**From:**  
**Sent:** 15 October 2025 19:24  
**To:** DC Admin  
**Subject:** FW: Attached letter from Kirklees Council regarding application number 2024/92031 at location Headlands Works, Headlands Road, Liversedge, WF15 7NT  
**Attachments:** CV-19 NNL (Amended Plan)\_2714.pdf; Ref: 2024/92031  
**Categories:**

**From:**  
**Sent:** 30 August 2024 07:47  
**To:** DC Admin  
**Subject:** Ref: 2024/92031

F.A.O Louise Bearcroft  
Case Officer  
Planning Dept.  
Kirklees MBC

DRAWING TITLE
FORWARD VISIBILITY - 23.0M

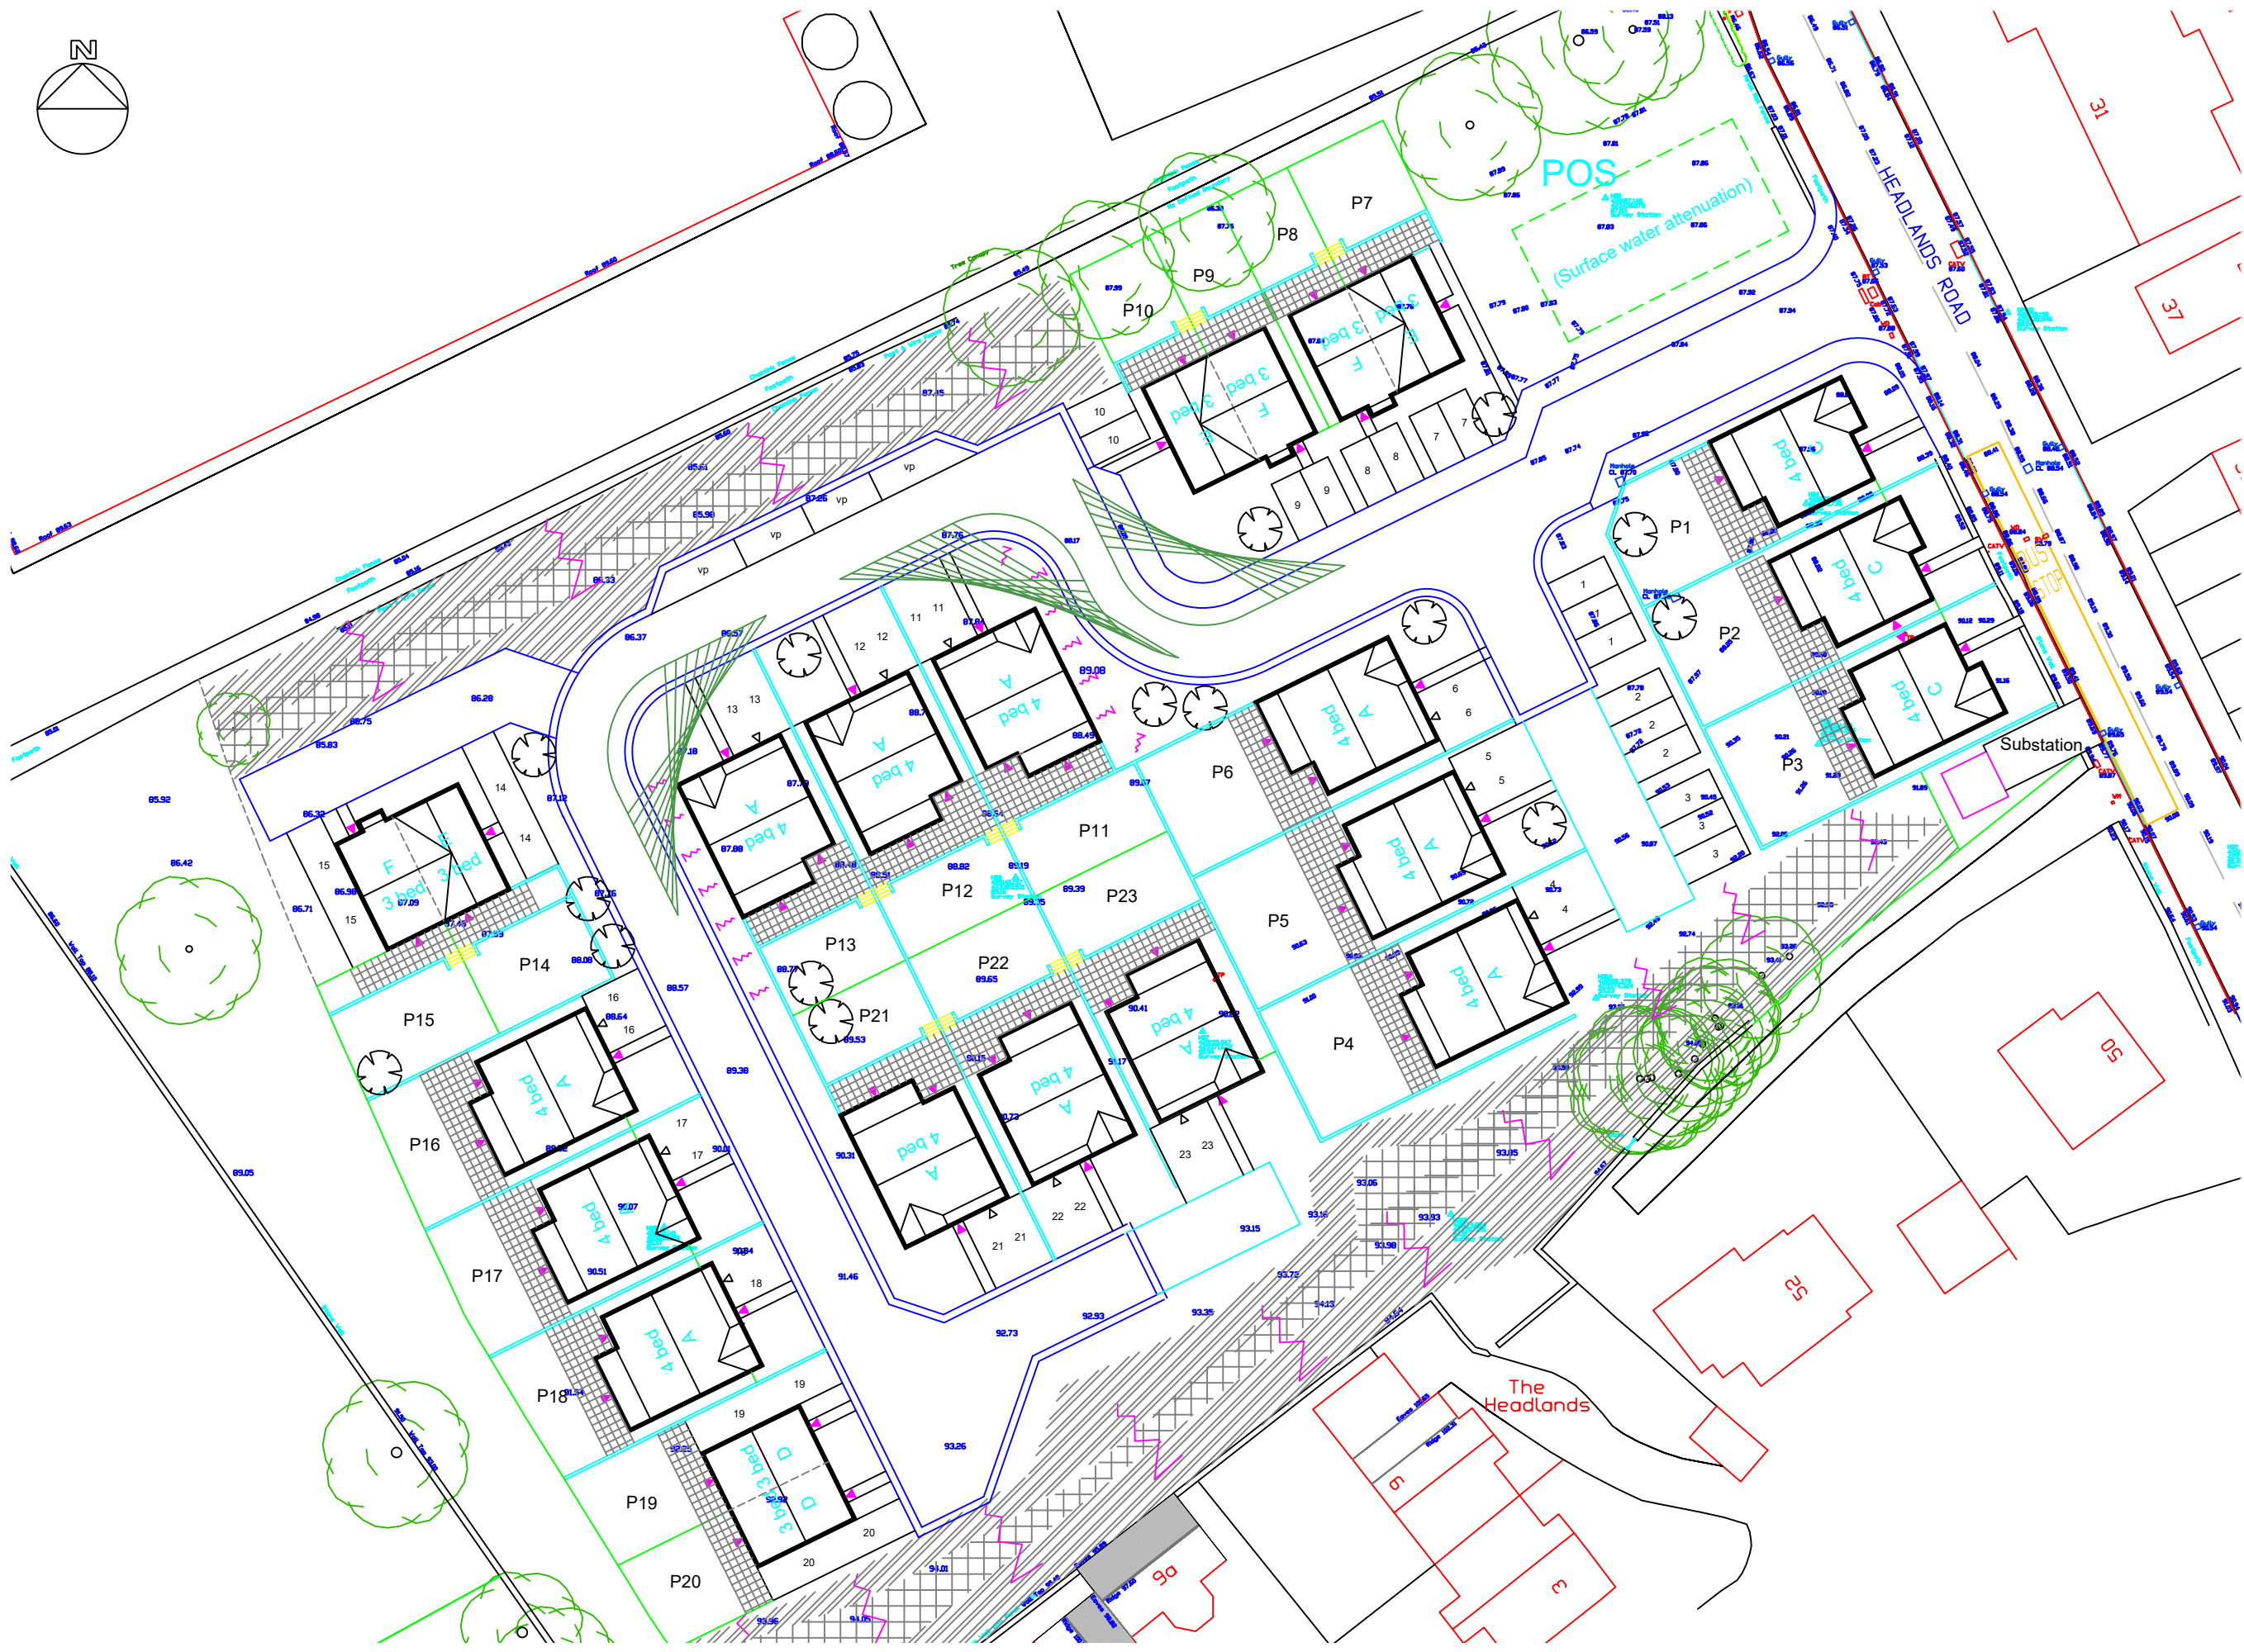
- Also, as I am very familiar with the topography of Headlands road, the sight lines coming out of the proposed development seems somewhat optimistic. The number of houses being sought and the sightlines onto Headlands Road would cause difficulty to road users coming and exiting into the development. Of course, I do not confess to be an expert and of course, that is a matter for Highways Dept at Kirklees.
